LAND TECHNOLOGIES, INC.

Response to Comments

Project Name: Undi Commerce Park
 Project File Number: PA22008 Technical Review 1
 Review Completion: April 27, 2022

SHEET **C3** of **C13**  
24x36  
PA22-008  
G2

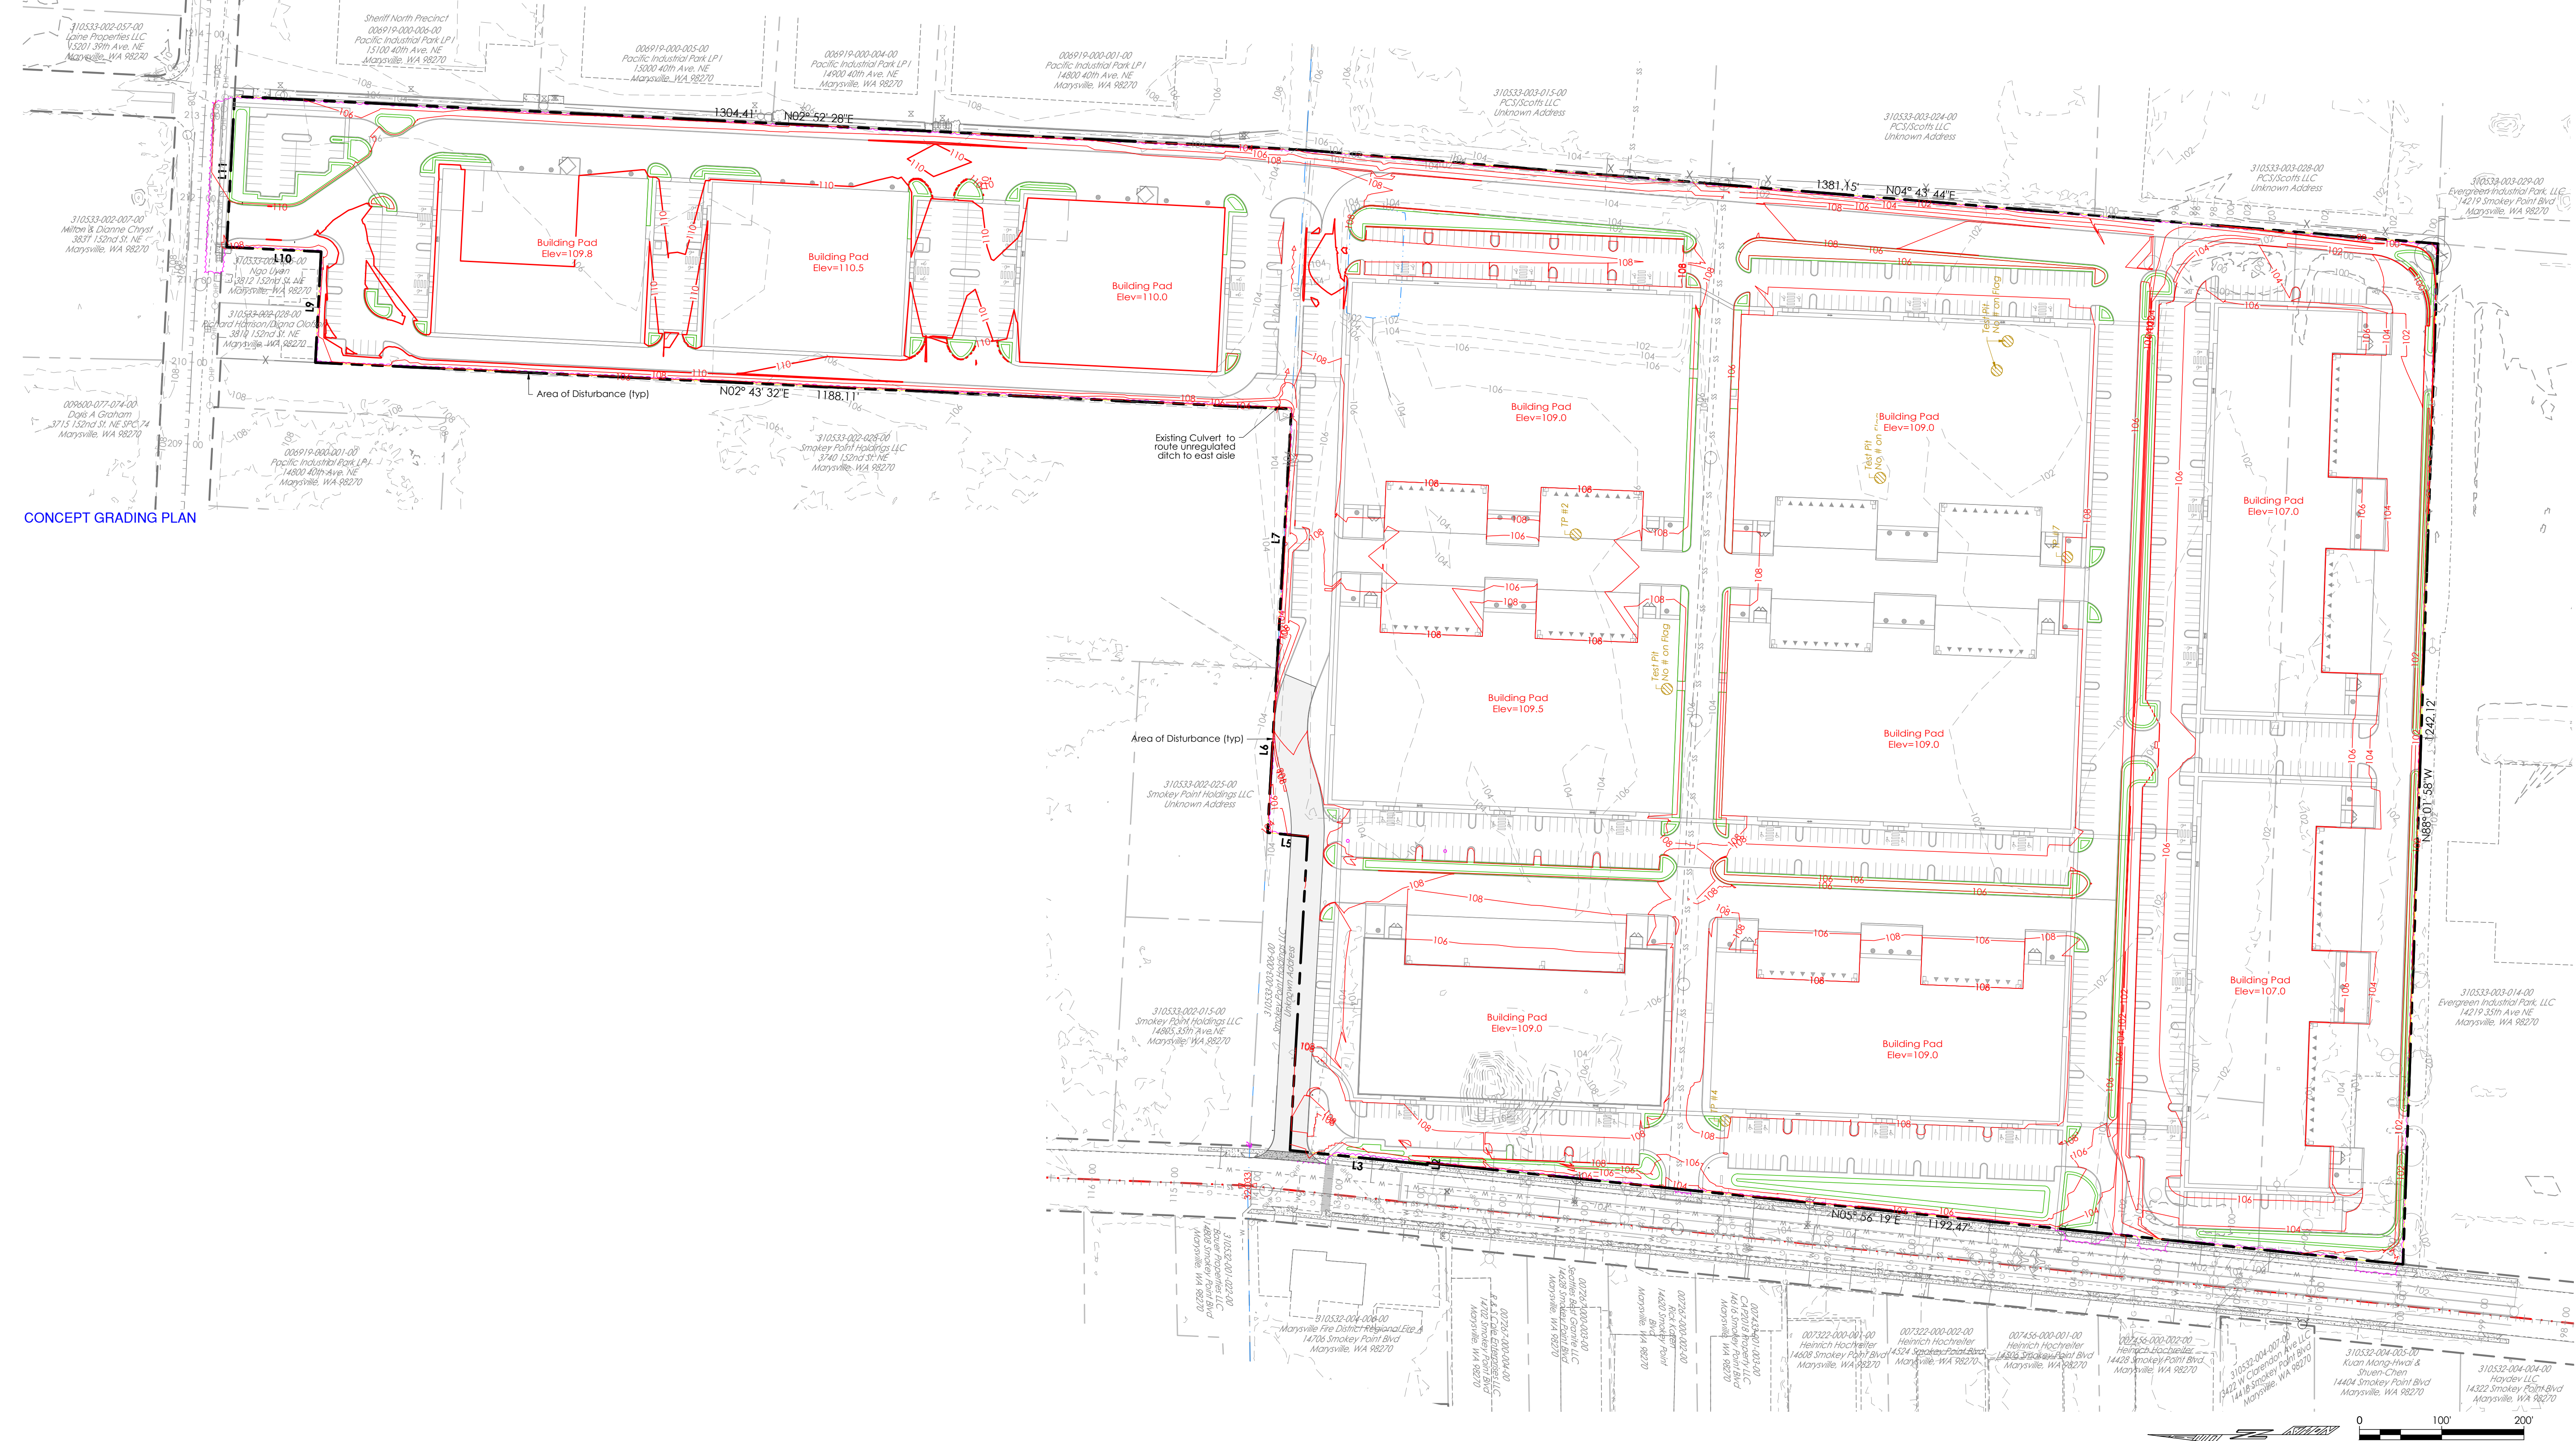
3. An existing conditions sheet will need to be provided, which depicts all encumbrances outlined in Schedule B of the Title Report prepared by Old Republic Title, Ltd., dated February 1, 2022. If the	Existing conditions/Topographic survey sheets have been added to the architectural plans package as sheets 1 of 7 prepared by Mead Gillman with encumbrances depicted or

CITY COMMENTS	LAND TECH RESPONSE
<p>encumbrances cannot be depicted they shall be referenced.</p>	<p>referenced. The encumbrances are also referenced on sheet C3 of the Concept Civil Plans, Existing Conditions sheet.</p>
<p>4. It appears UPC is proposing two 30' wide accesses through APN 31053300302400 to 40th Street NE. Please provide a copy of the recorded access easement between UCP and APN 31053300302400. 40th Street NE is failing and directing trips to this roadway may not be desired by Public Works. Access from UPC through APN 31053300302400 to 40th Street NE will be required to be approved by the City Engineer.</p>	<p>See architectural response letter.</p> <p>“We are currently in the process of negotiating an easement (between UCP and APM 31053300302400) with the adjacent property owner (PCS-Scotts LLC) and his lender, regarding the structure of the easement. We will provide the easement agreement upon signing it (expected end of May 2023).”</p>
